**From:** [Connor Armi](#)  
**To:** [Zach Torrance-Smith](#)  
**Cc:** [Guy Moura](#); [Hanson, Sydney \(DAHP\)](#)  
**Subject:** Re: SP-24-00008 Frosty Pines II - Notice of Application  
**Date:** Wednesday, May 22, 2024 3:09:34 PM

RE: SP-24-00008 Frosty Pines II

**TO:** All Staff  
**FROM:** Public Works Plan Review Team  
**DATE:** May 30, 2024  
**SUBJECT:** SP-24-00008 Frosty Pines II

FROSTY PINES II			
SP-24-XXXX			
FROSTY PINES, LLC			
SE 1/4 NW 1/4 AND NE 1/4 SW 1/4 OF SECTION 16, T.21 N., R.14 E., W.M.			
SURVEYED BY: JC	DRAWN BY: SW	CHECKED BY: VW	APPROVED BY: SW
DATE: MARCH 2024	APPROX. JOB NO.: 1565.005	ACAD NAME: 1565005SP	
			SHEET 2 OF 3

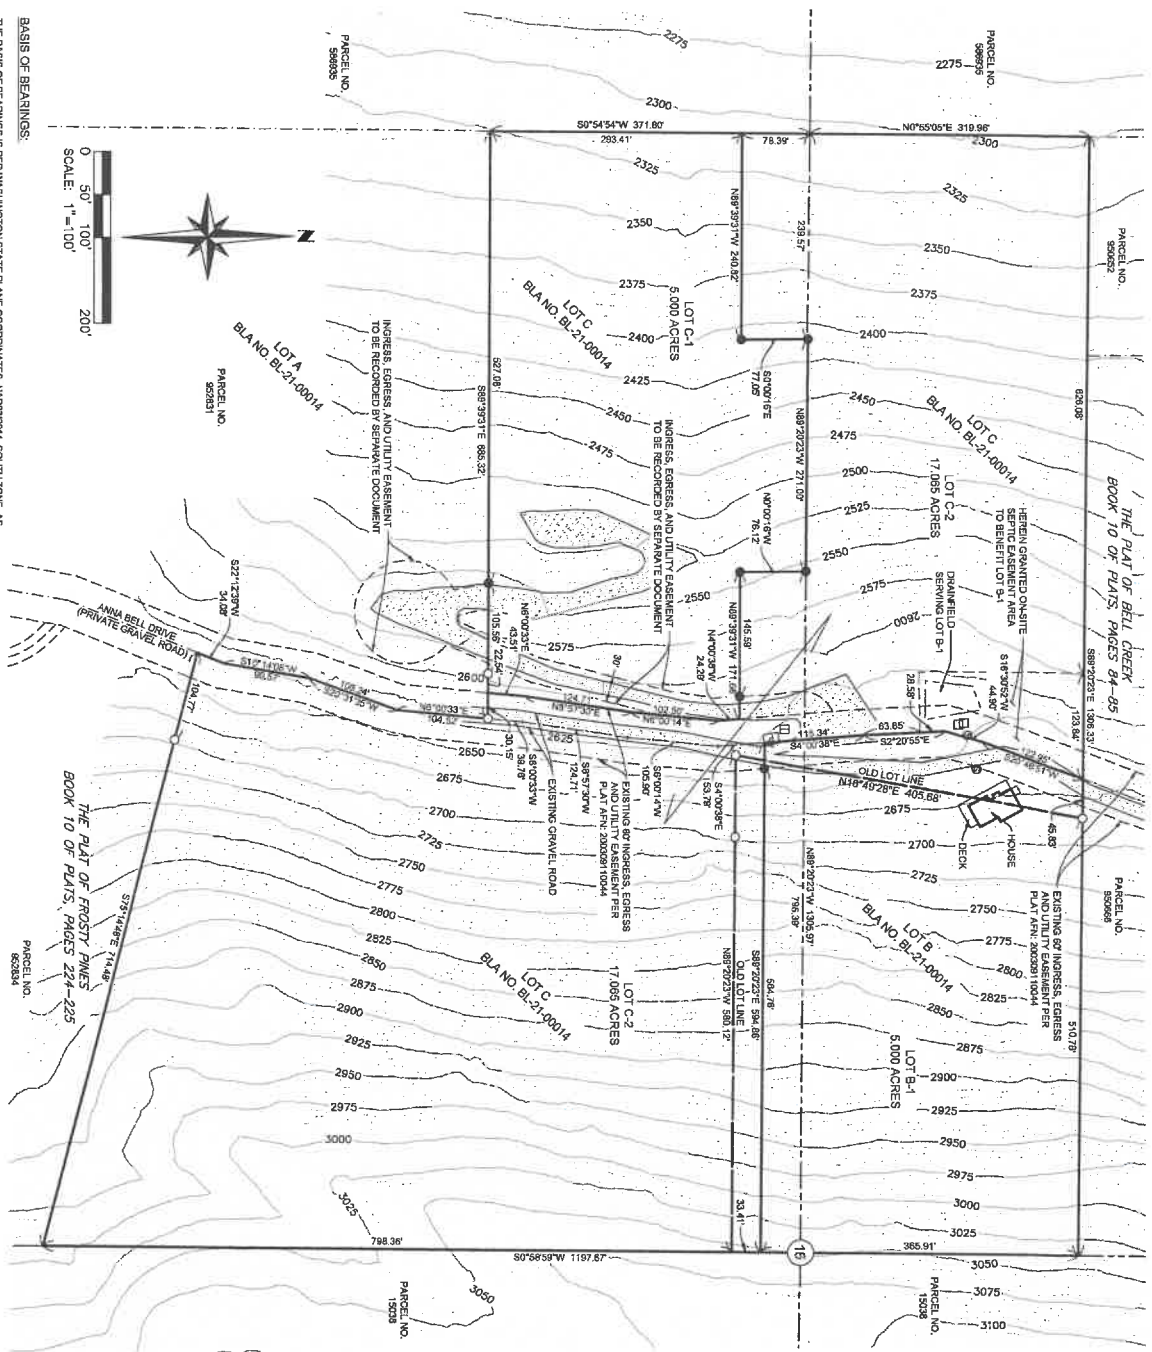
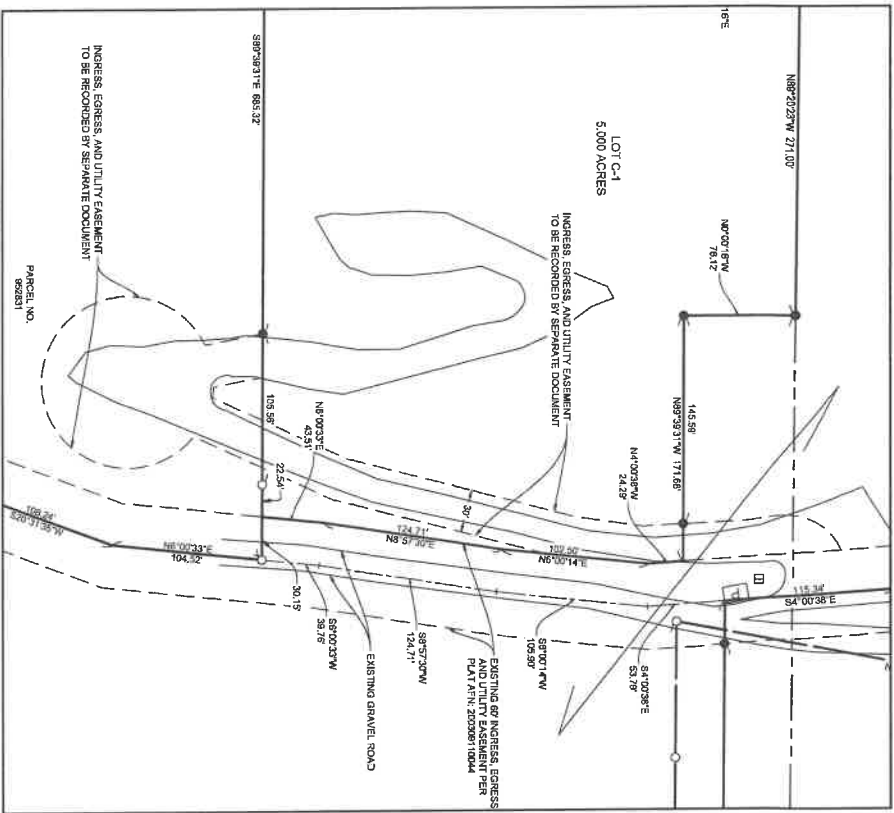
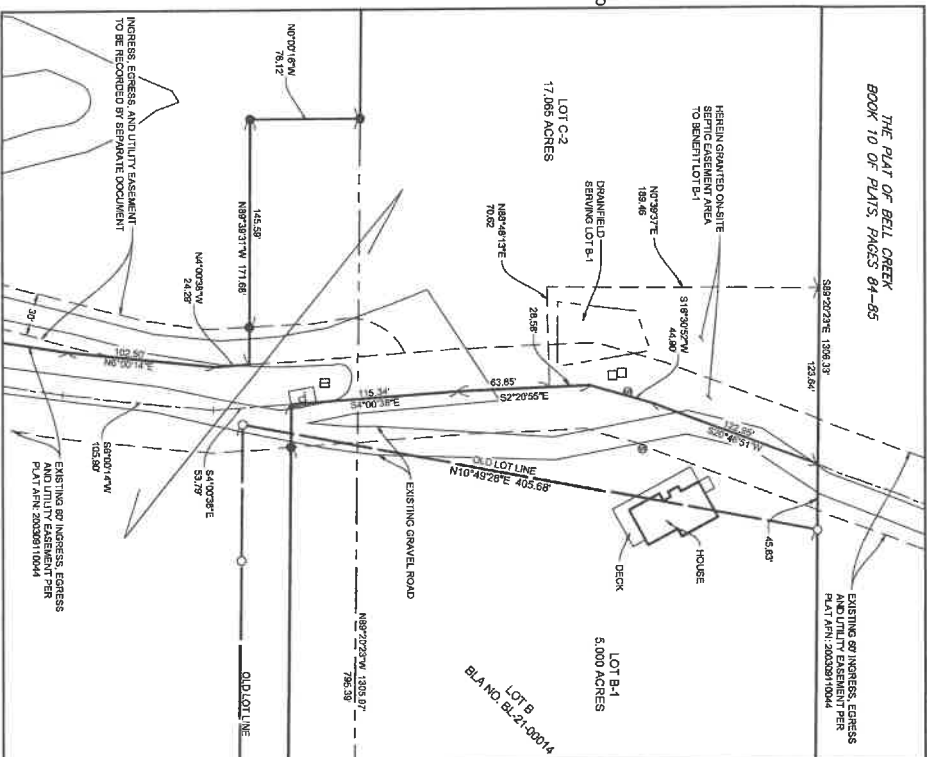
<b>SURVEY</b>	<p>The application meets the requirements of the Prelim Short Plat.</p> <p>The following will need to be addressed prior to final:</p> <ol style="list-style-type: none"> <li>1. The Easement shown to be recorded via separate document is not mathematically retraceable from the Short Plat. Please ensure that the easement document includes a retraceable description and does not simply refer to the Short Plat.</li> <li>2. At minimum, the new division lines shall show corners, and have them set in the field. This includes the NW corner of Lot C-1 and the SE corner of Lot B-1.</li> <li>3. The existing parcel (Lot B and C) are referenced to the record documents as BLA No. BL-21-00014. As this number is an internal application number to the county, these references should include Book and Page (B:44 Surveys, P:11) or the Assessor's File No. (AFN:20217230120). This occurs on the face of the map as well as the basis of bearings statement.</li> </ol> <p>OF NOTE</p> <p>While vicinity maps are specifically excluded from text height legibility requirements, it would certainly clarify things to increase the text height to a more legible size.</p>
